Consultation Response from KC, Ecology Unit
2023/93388 Dene End Funeral Home, 50, North Road, Kirkburton, Huddersfield, HD8 0RW
Change of use from domestic to commercial, demolition of existing workshop and erection of three storey office building (within a Conservation Area)
Date Responded: 03/05/2024 Responding Officer: Gareth Hey Responding Ref:

DRAWING TITLE
PROPOSED BAT & SWIFT BOX PLAN

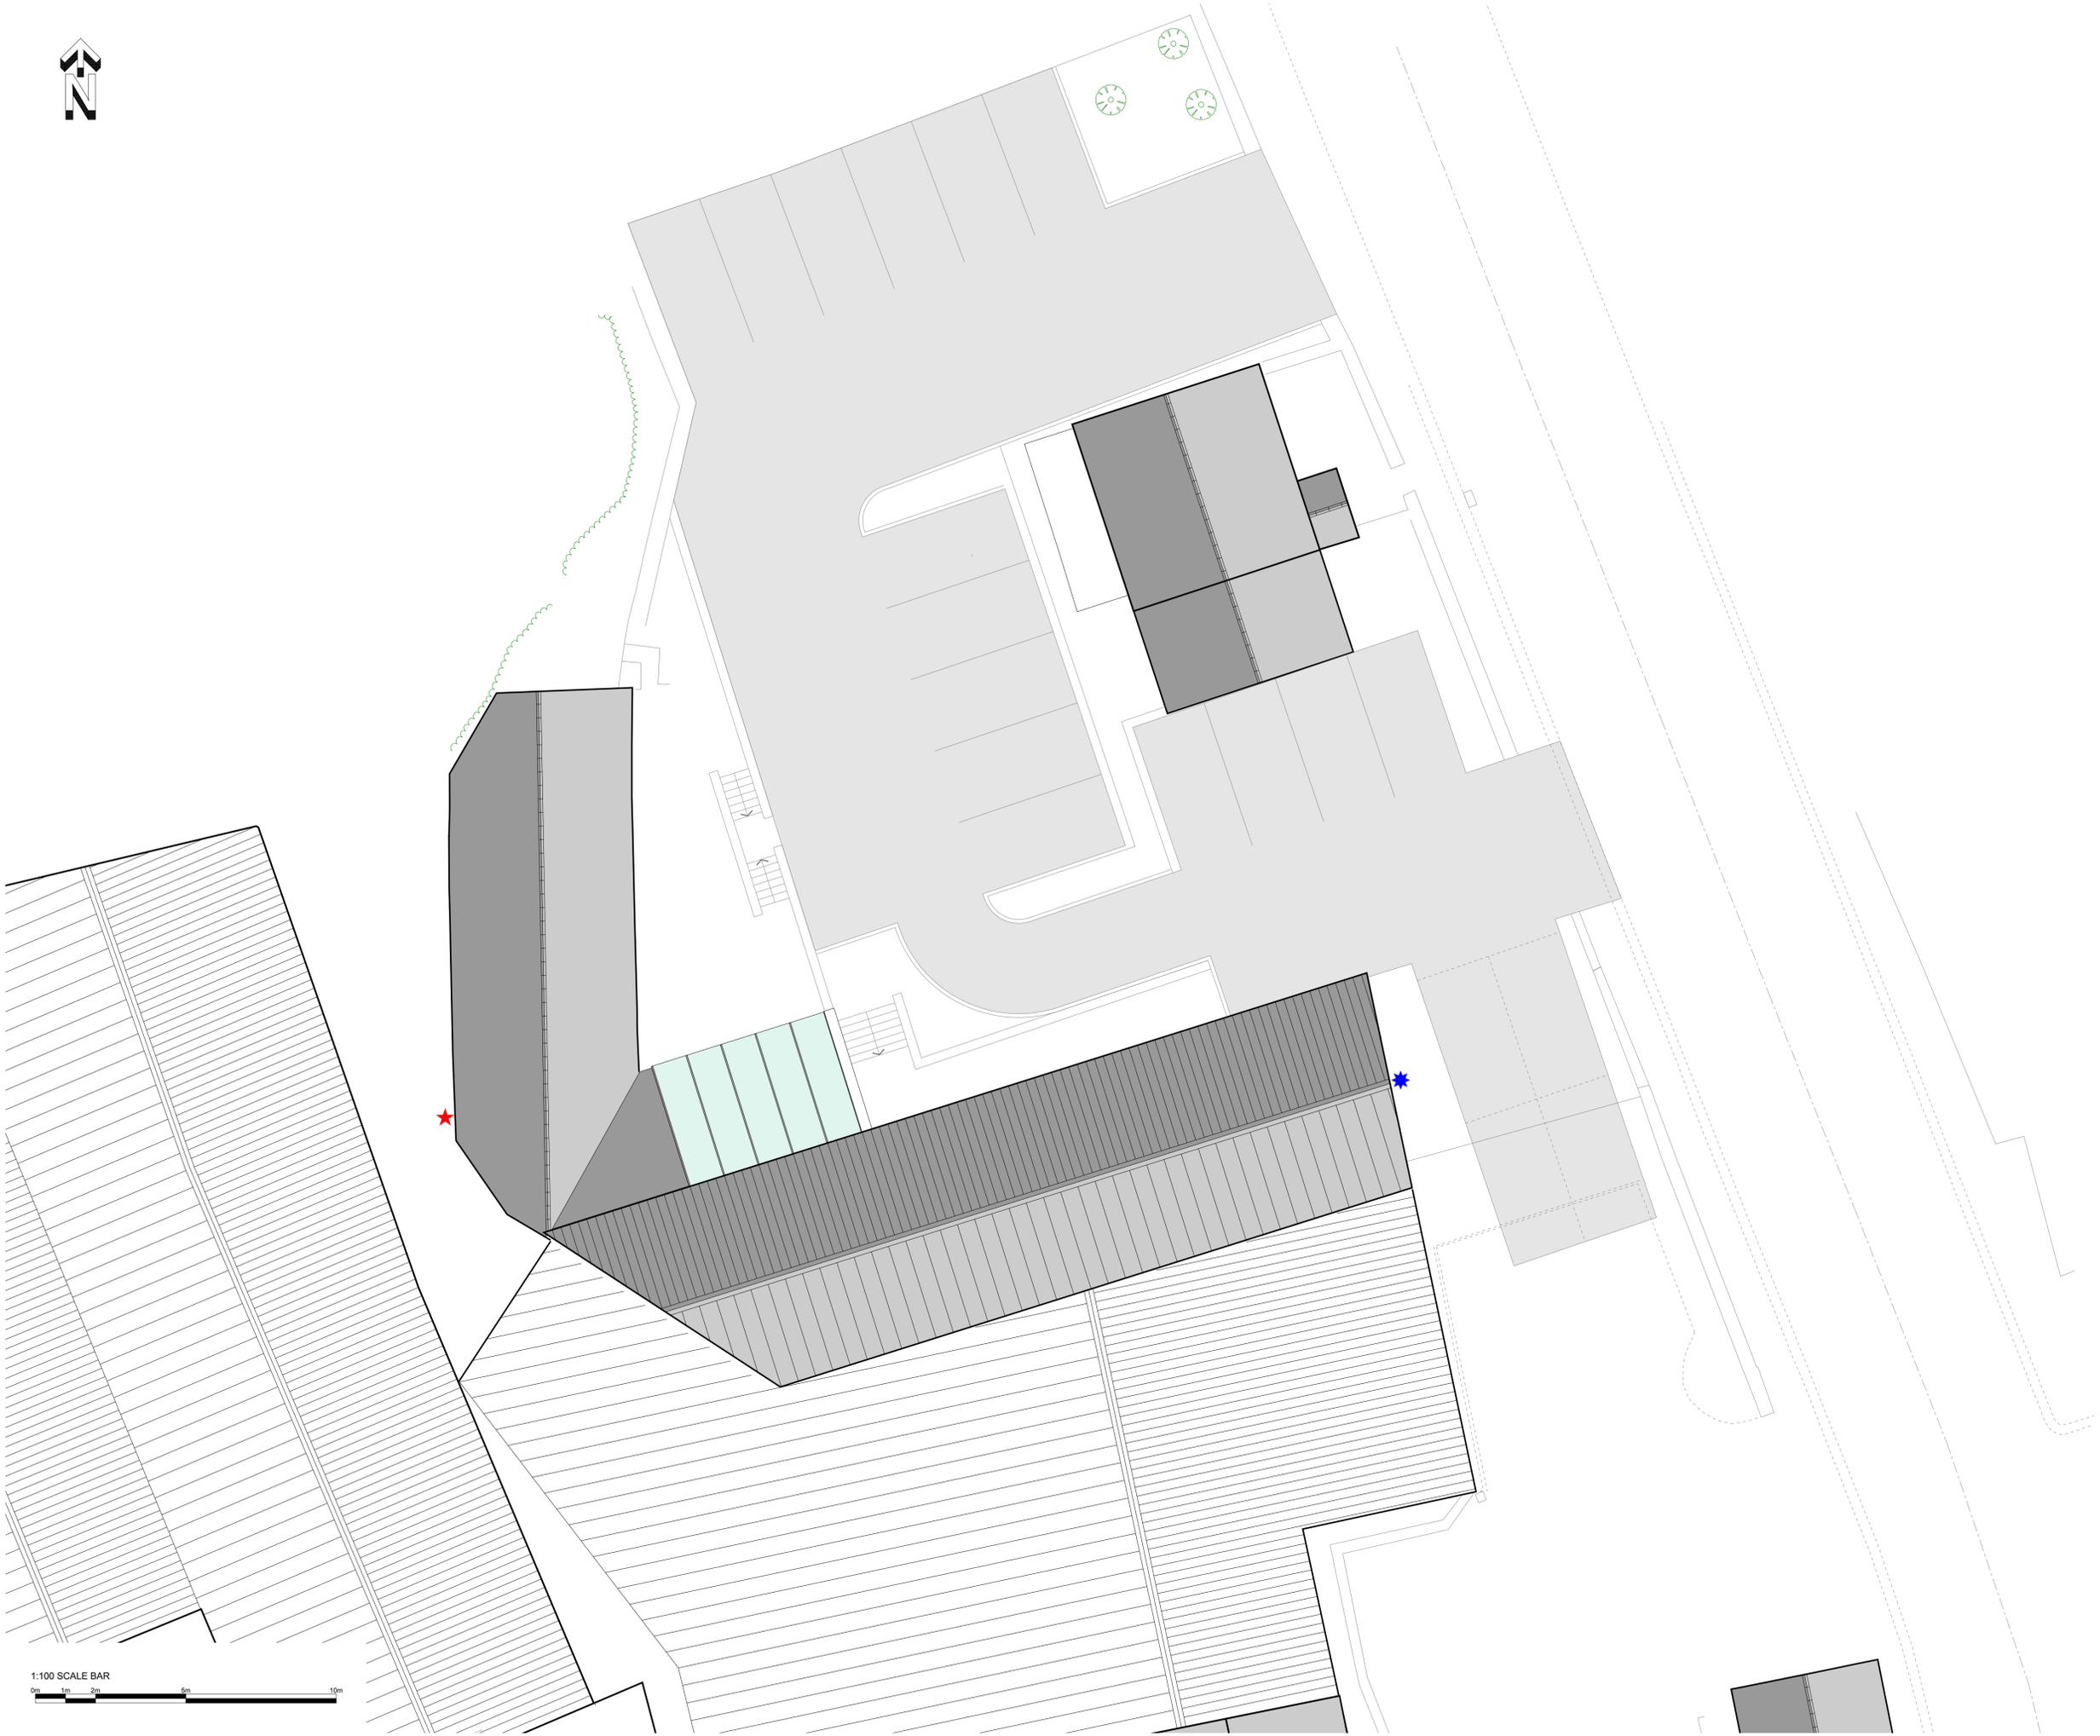
2. Prior to the commencement of development, a plan detailing the specification, positioning and location of one integrated bat box (Ibstock Enclosed Bat Box 'C' or suitable alternative) and one integral swift box (Vivara pro Woodstone swift box or suitable alternative) shall be submitted to and approved in writing to the local authority.
